From: Colin Chandler [REDACTED]
Sent: 26 October 2018 15:55
To: Planning.Responses; [REDACTED]
Cc: Karl Roberts
Subject: 53 Mill Road Avenue, Angmering BN16 4HX

RE: 53 Mill Road Avenue, Angmering, BN16 4HX
Application numbers: A/128/18CLE & A132/18HH

Issue	Details	By	Date
SCALE		AS SHOWN ON	
DATE			06/09/1
DRAWING NUMBER			15060/LI

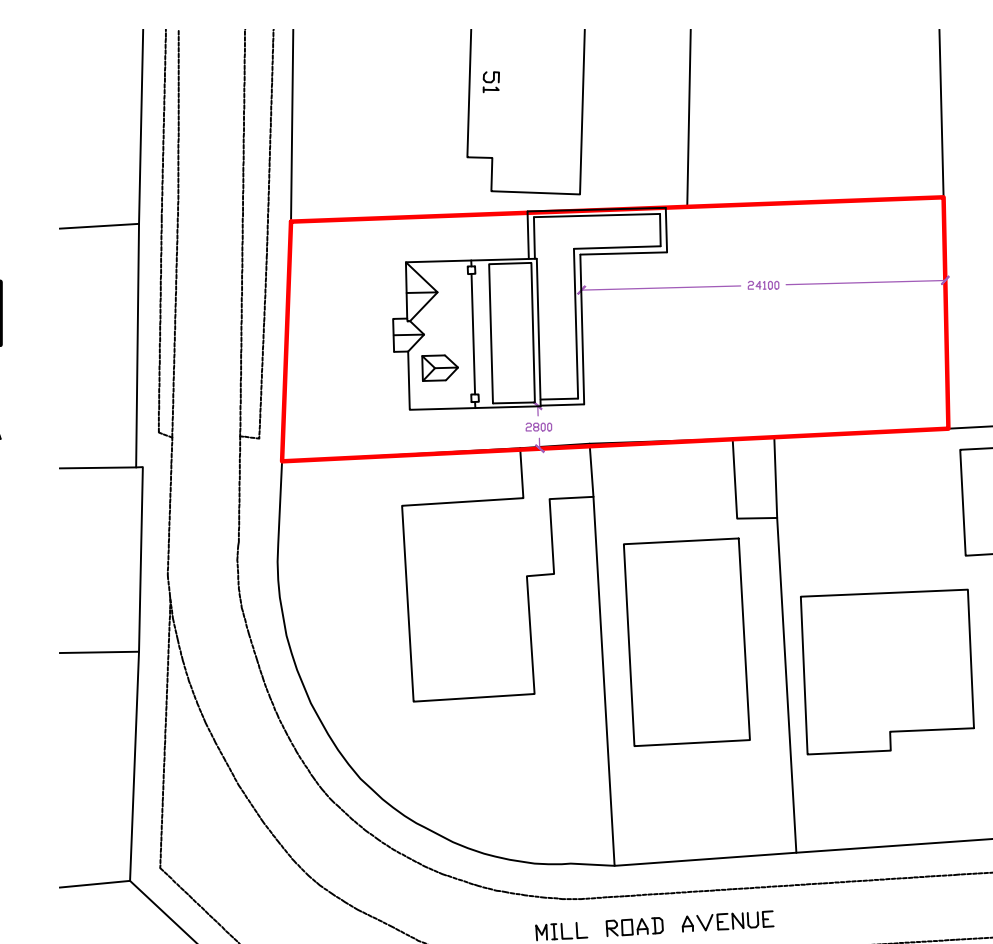
Whereas the "REAR ELEVATION East" on drawing 15060/LDC submitted with application A/128/18CLE shows the dormer as extended with window/door openings, that is not replicated on drawing 15060/02R3 submitted with application A/132/18/HH that simply shows the dormer as previously existing and the approved single storey addition. We are not clear whether the openings we saw formed in the extended dormer before the protective sheeting was added reflect that shown on drawing 15060/LDC and are indeed the final choice, but in any event their design and with the added French doors (presumably as a Juliet style balcony) also seriously begs the question as to whether the advice contained in the second bullet point of the Government's Technical Guidance supporting Class B.2(a) of the GPDO as to whether the interpretation has been fully respected:

- *"The face and sides of a dormer window should be finished using materials that give a similar visual appearance to existing house. So the materials used for facing a dormer should appear to be of similar colour and design to the materials used in the main roof of the house when viewed from ground level. Window frames should also be similar to those in the existing house in terms of their colour and overall shape." (Our underlining)*

Given the French doors could easily afford access to the roof of the approved single storey extension (if built) and thereby harm neighbouring privacy, we trust that in the event a planning permission were to be granted for the dormer a suitable condition would be imposed to restrict such potential.
